WEST SUSSEX COUNTY COUNCIL CONSULTATION

TO:	Arun District Council FAO: Ms M Tomalova
FROM:	WSCC - Highways Authority
DATE:	7 July 2021
LOCATION:	Bowley Farm Bowley Lane South Mundham Chichester PO21 1NB
SUBJECT:	P/95/21/PL Retention of 4 mobile homes for countryside workers together with drainage and service connection provision in connection with permission P/72/09 as varied by P/22/017/PL (resubmission following P/86/20/PL). This site is in CIL Zone 5 (Zero Rated) as other development.
DATE OF SITE VISIT:	n/a
RECOMMENDATION:	Advice
S106 CONTRIBUTION TOTAL:	n/a

SITE PLAN
1:500 @ A2

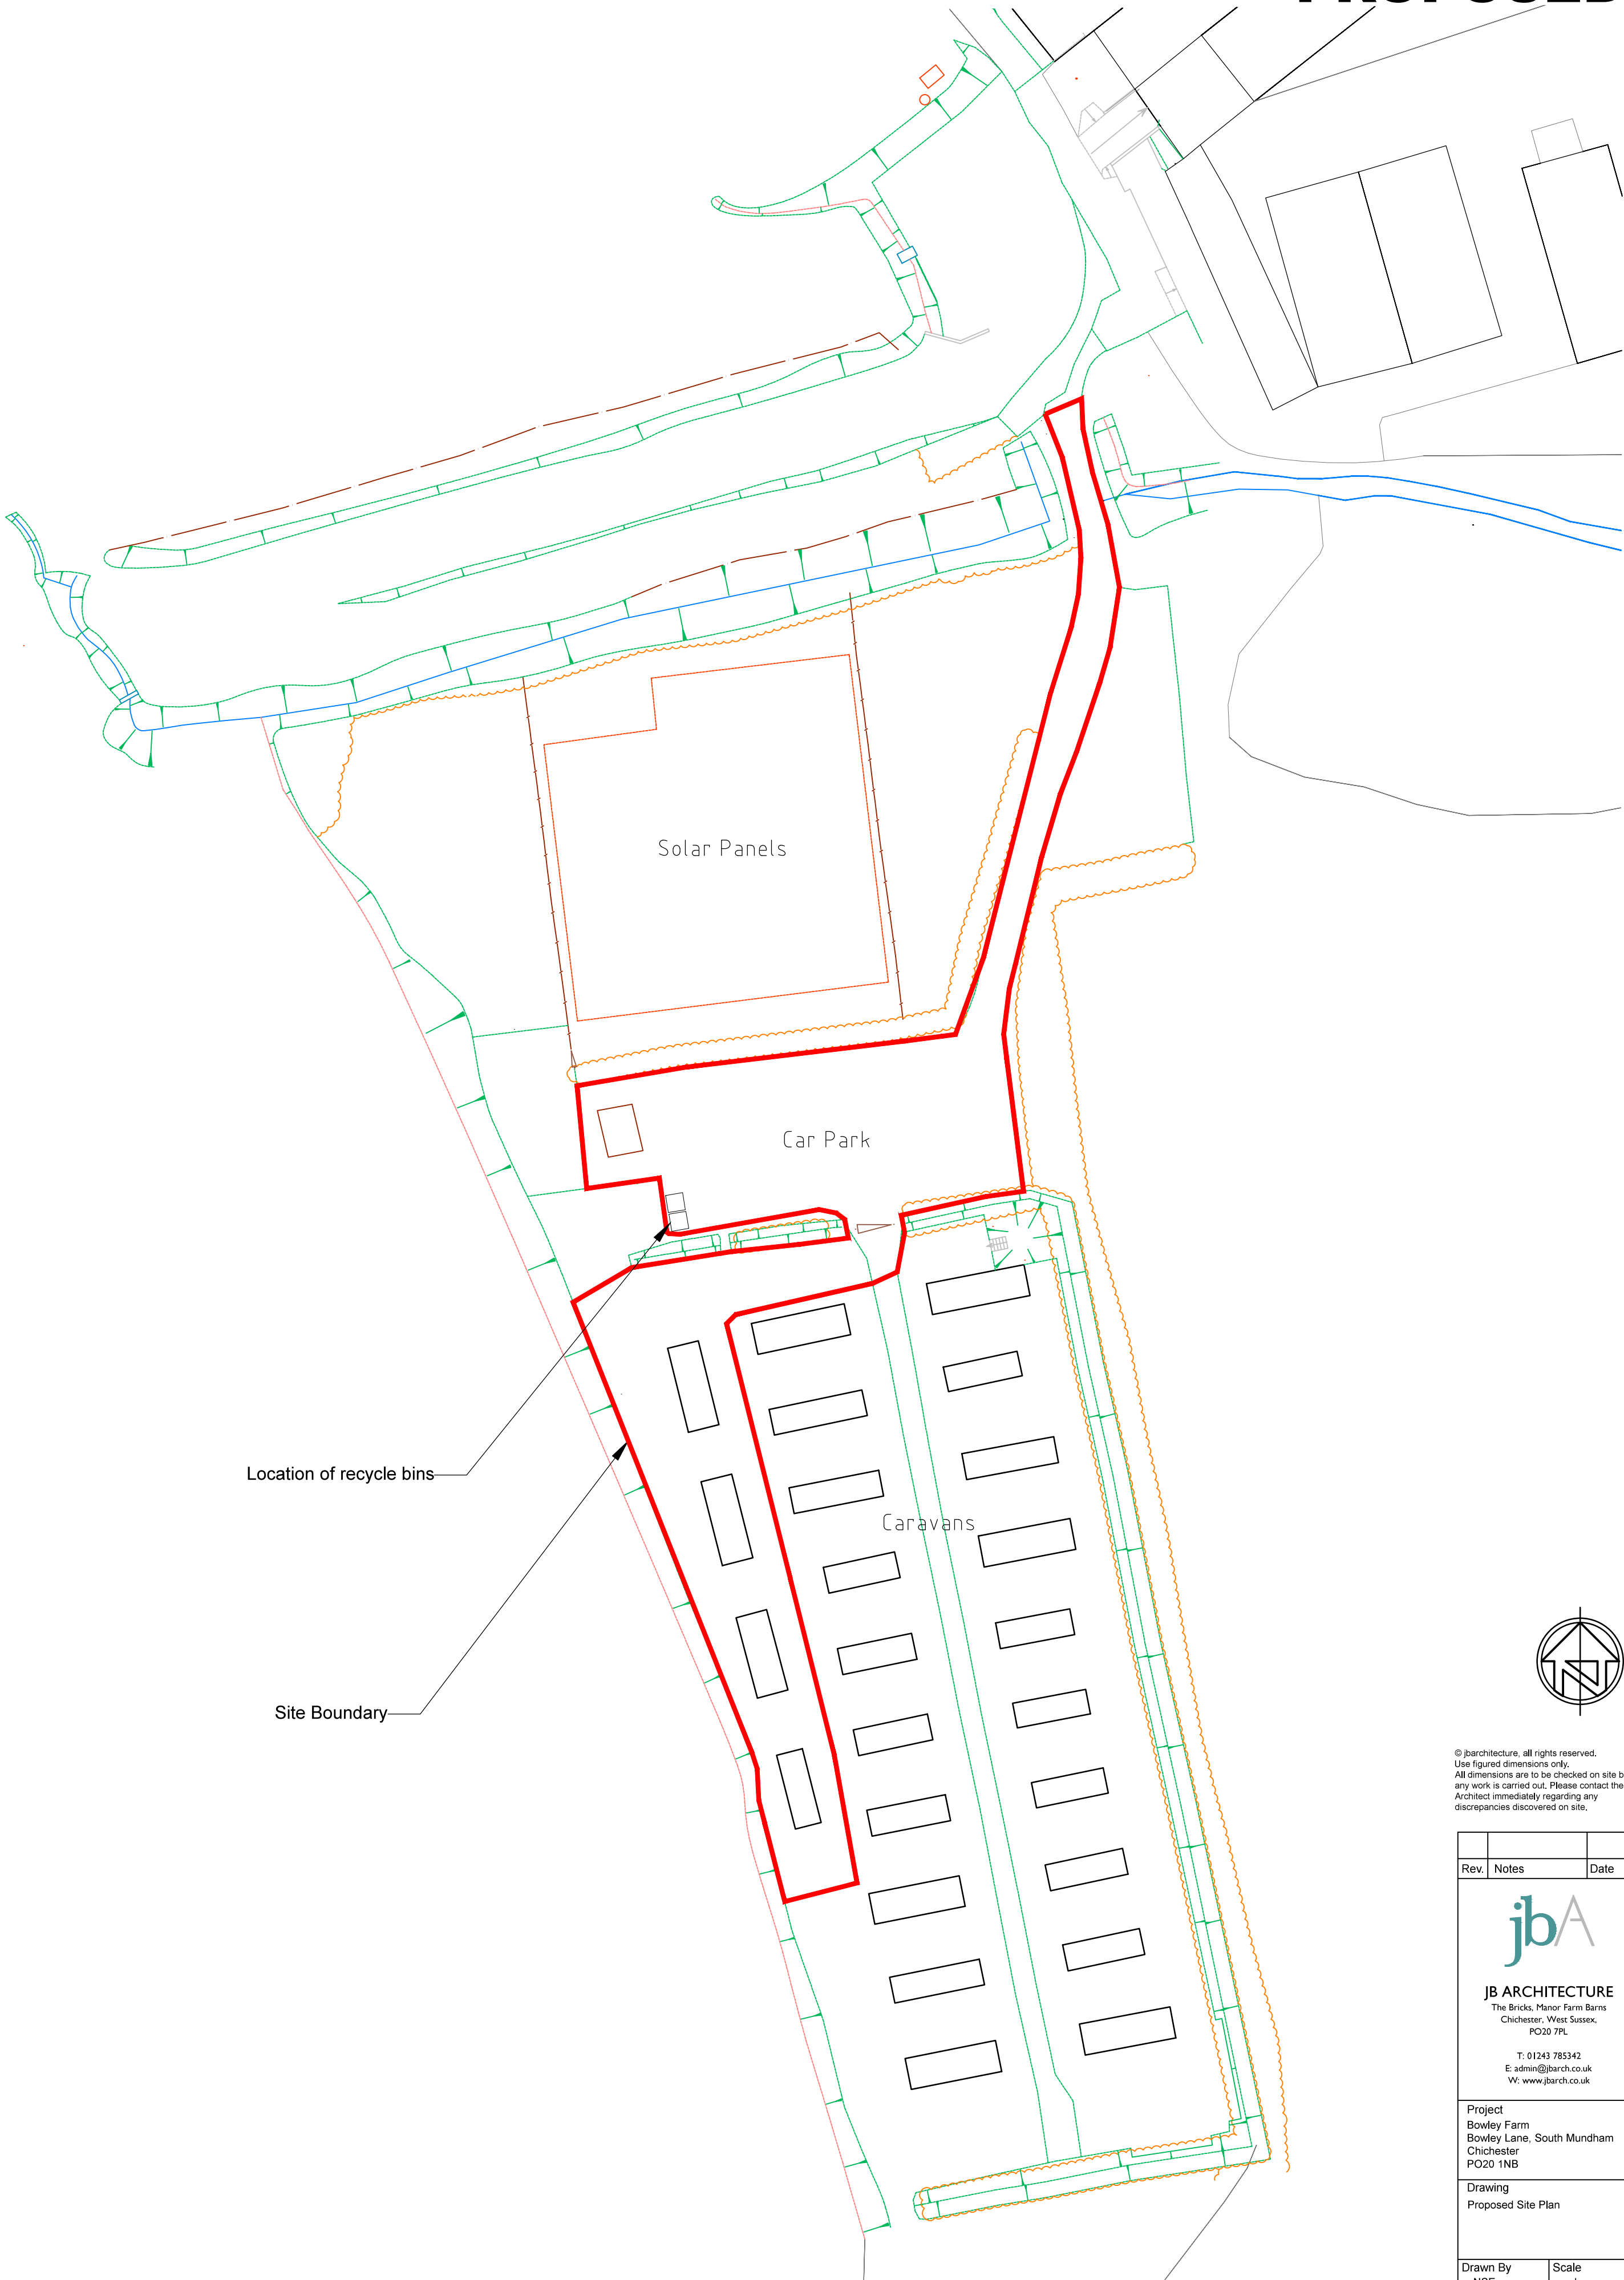
WSCC Local Mapping and the submitted plans show a hardstanding area located to the North (annotated as parking) large enough to accommodate any parking provisions of the site.

The applicant has not demonstrated details of any cycle parking provision. The LHA advises the Local Planning Authority (LPA) that if they deem cycle parking justifiable then the applicant should show this in the form of lockable covered storage. Details of which can be secured with a suitably worded condition.

In the interests of sustainability and as result of the Government's 'Road to Zero' strategy for at least 50% of new car sales to be ultra-low emission by 2030, electric vehicle (EV) charging points should be provided for all new homes. The applicant is advised that for dwellings with an off-street parking provision, 100% of parking spaces should be provided with active EV parking spaces in accordance with the Arun Parking Standards (adopted January 2020). The LHA would be minded to suggest that the details of which could be secured with a suitably worded condition.

Within 6 months of permission electric vehicle charging space(s) shall be provided in accordance with plans and details to be submitted to and approved by the Local Planning Authority.

Within 6 months of permission covered and secure cycle parking spaces shall be provided in accordance with plans and details to be submitted to and approved by the Local Planning Authority.
